Outline application with all matters reserved for 6 No detached houses with detached garages. This application is a Departure from the Development Plan.

Former Lanes End House Adjacent to West Walberton Lane & Arundel Lane Walberton

Thank you for your internet representation made on 29th May 2018 which has been recorded as **'an objection'** with the comments as follows:

Former Lanes End - Six Six bedroom detached Houses with Garages Proposed Layout Scale 1:100 @ A3 (c) PJ Developments LTD 2018		REVISIONS		01
		MM/DD/YY	REMARKS	
	1	--/--/--	...	A
	2	--/--/--	...	
	3	--/--/--	...	
	4	--/--/--	...	
	5	--/--/--	...	
West Walberton Lane Proposal

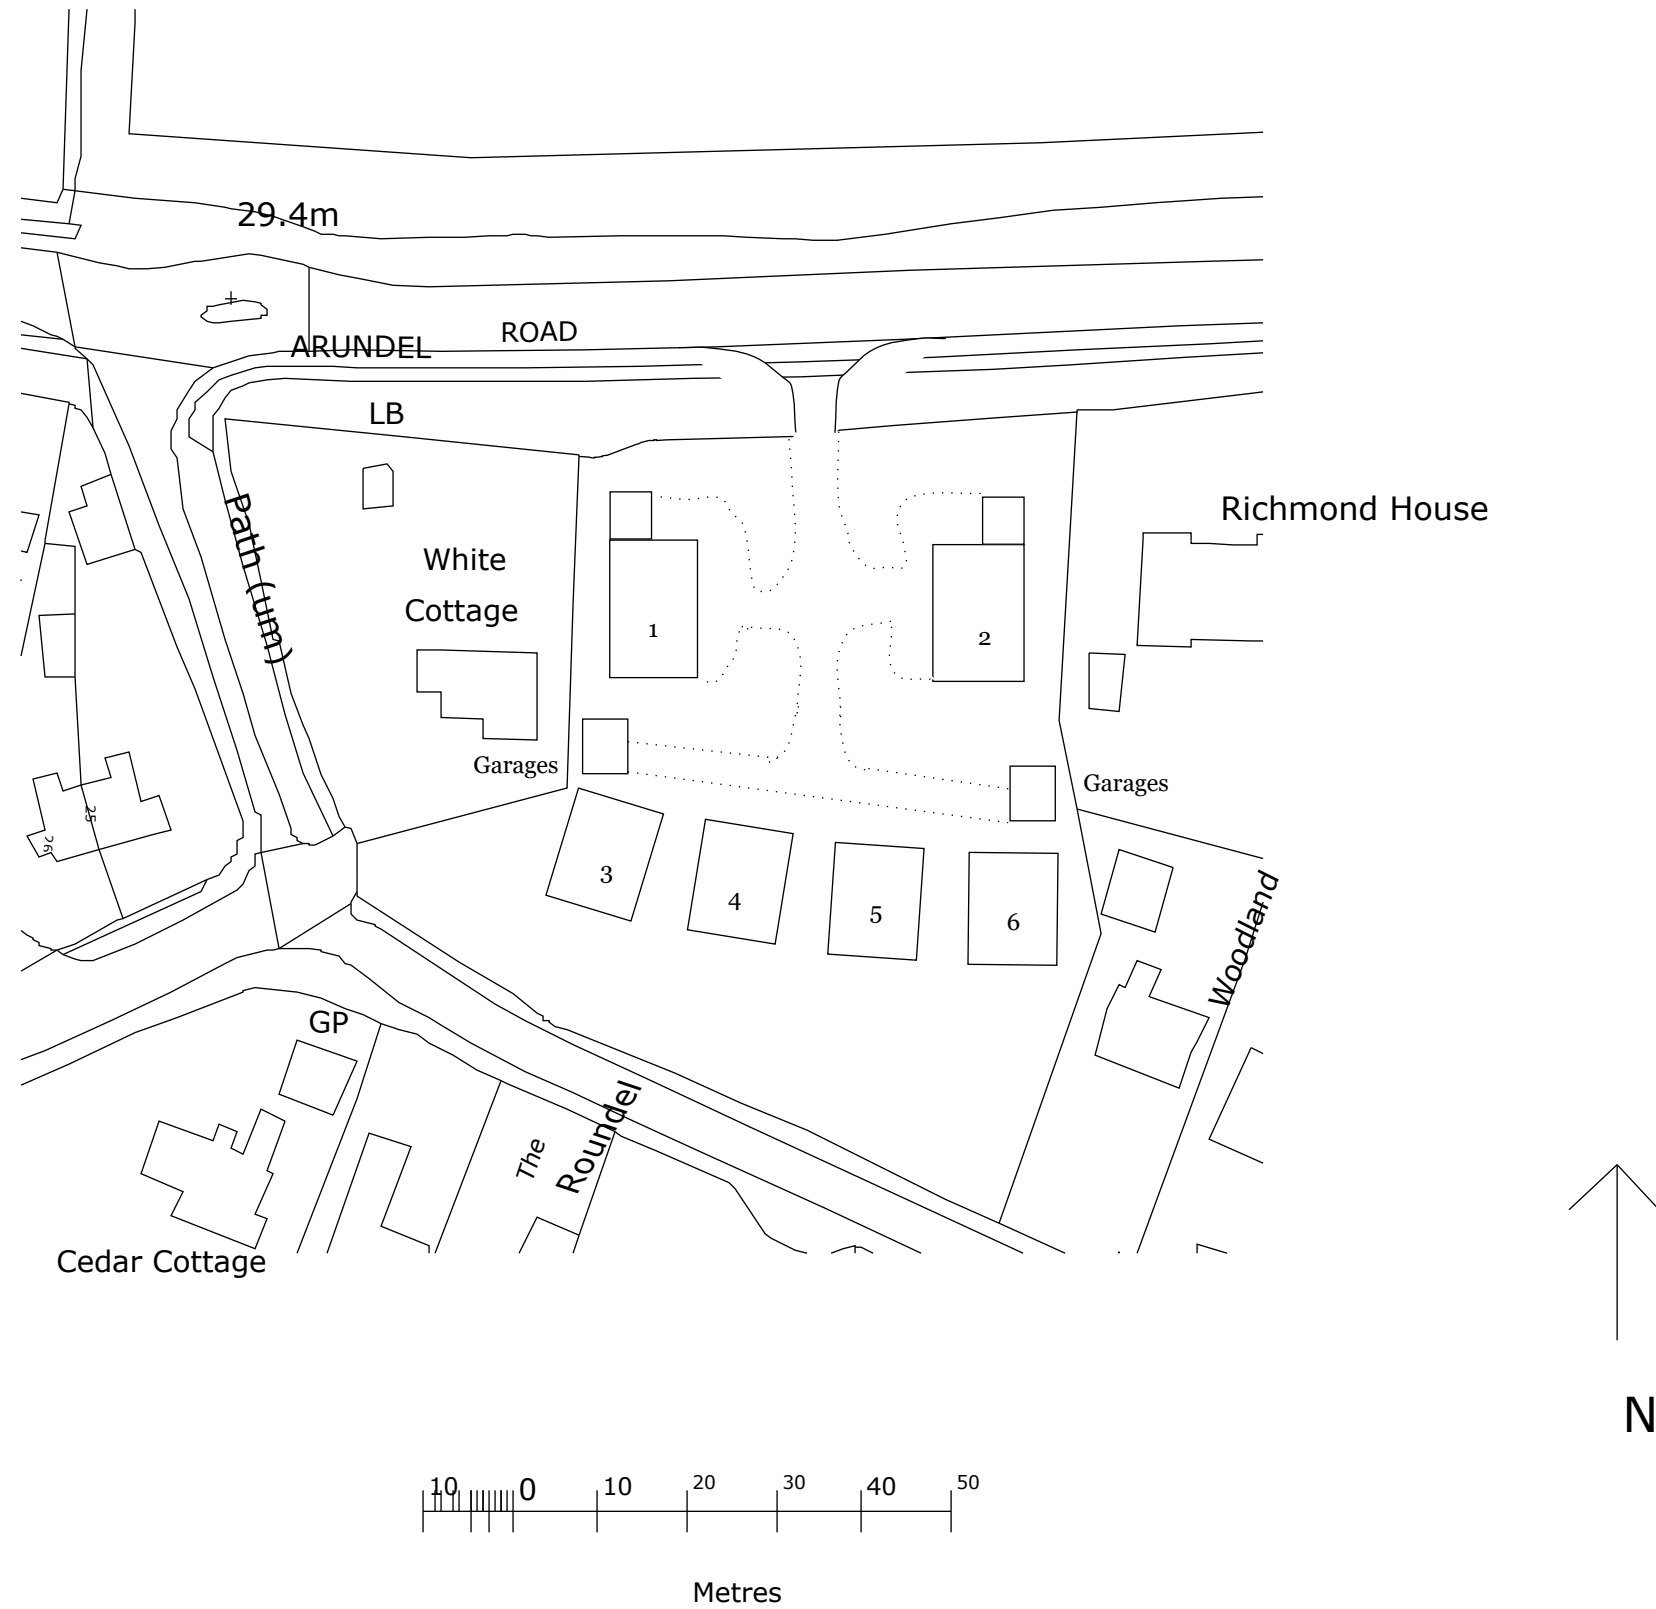
I object to this development as it is overdeveloping the area and totally uncharacteristic and not in keeping with the surroundings. Unit 1 & 2 are over-sized for the plots they are situated on. 3 of the units are very close to neighbouring properties and will be overbearing due to the height of the houses. This development will spoil the village and is not a place large housing developments.
